**RE: CHARTER BANK (E17-D56). ENGINEER'S CERTIFICATION FOR  
CERTIFICATE OF OCCUPANCY APPROVAL. ENGINEER'S STAMP DATED  
JULY 8, 1999.**

**RE: CHARTER BANK, ONE PRESIDENTIAL PLAZA (E17-D56). DRAINAGE REPORT FOR  
ROUGH GRADING, FOUNDATION PERMIT, AND BUILDING PERMIT APPROVALS.  
ENGINEER'S STAMP DATED MAY 1, 1998.**

**DRAINAGE REPORT FOR  
CHARTER BANK  
ONE PRESIDENTIAL PLAZA**

**Charter Office Building**  
4400 Osuna Road NE  
Albuquerque, New Mexico 87109  
**GRADING / DRAINAGE PLAN**

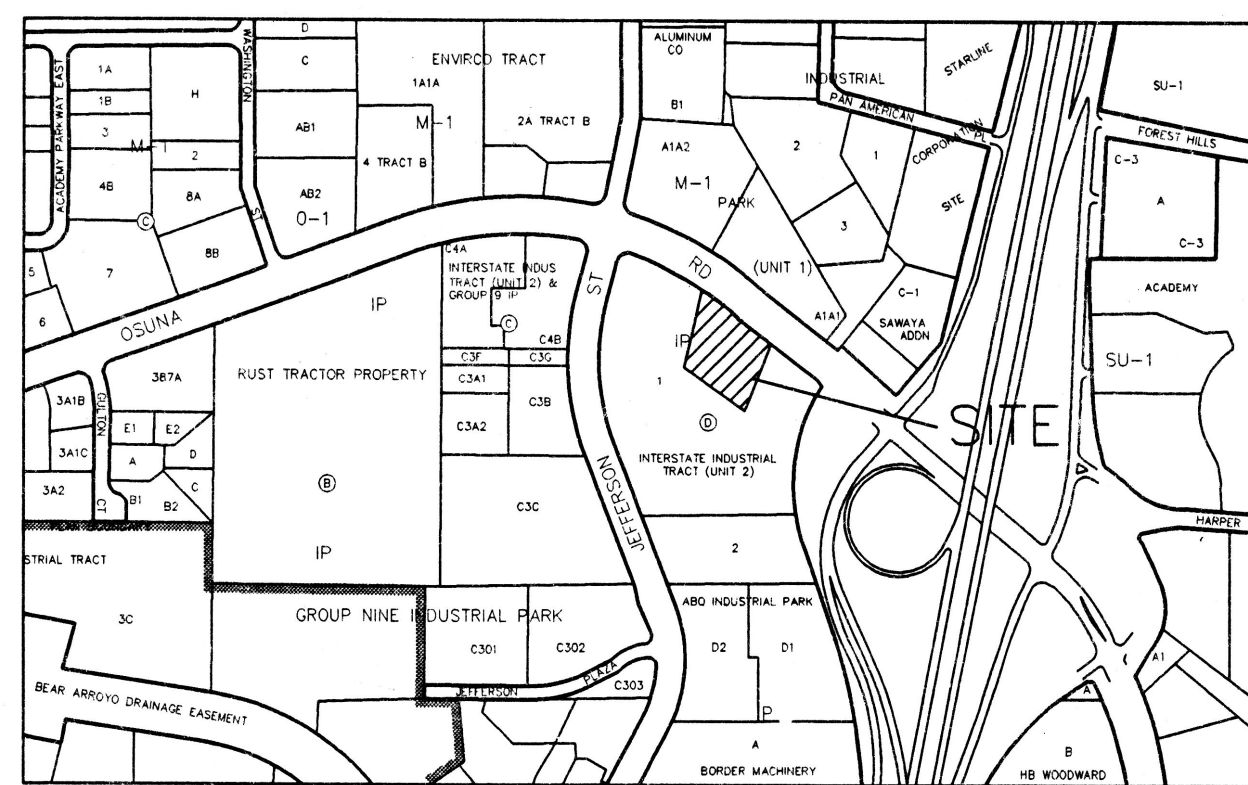
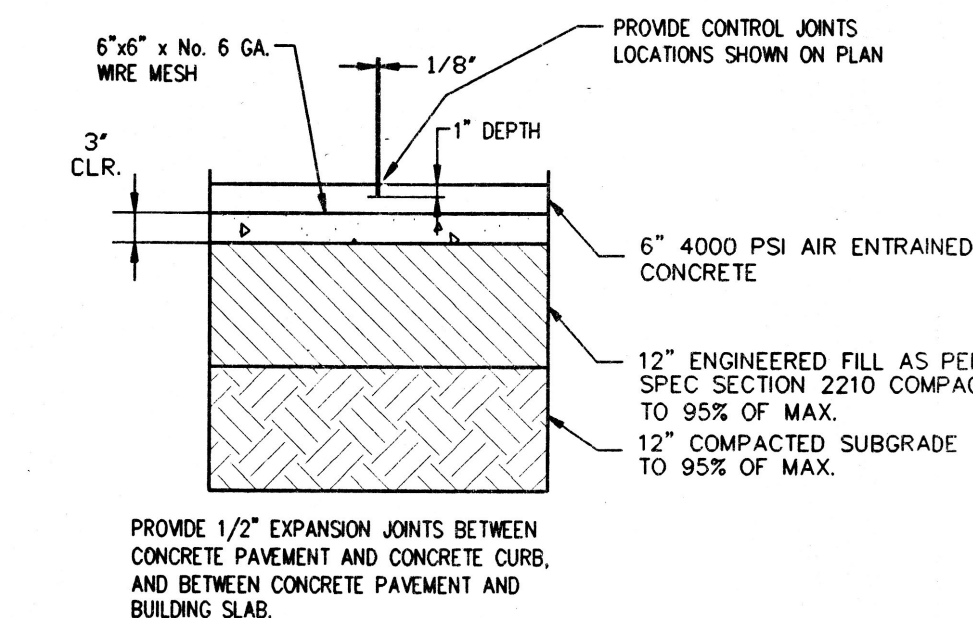
Note on G&D Plan for Charter Bank that it is Basin B of Master Drainage Plan for One Presidential Plaza. Both G&D and Detail Plans are labeled Sh. A1.1. Indicate maximum water depth on typical pond cross-section detail. As presently configured, fencing of the ponds will be required (See enclosed p.170 of Rev.DPM).
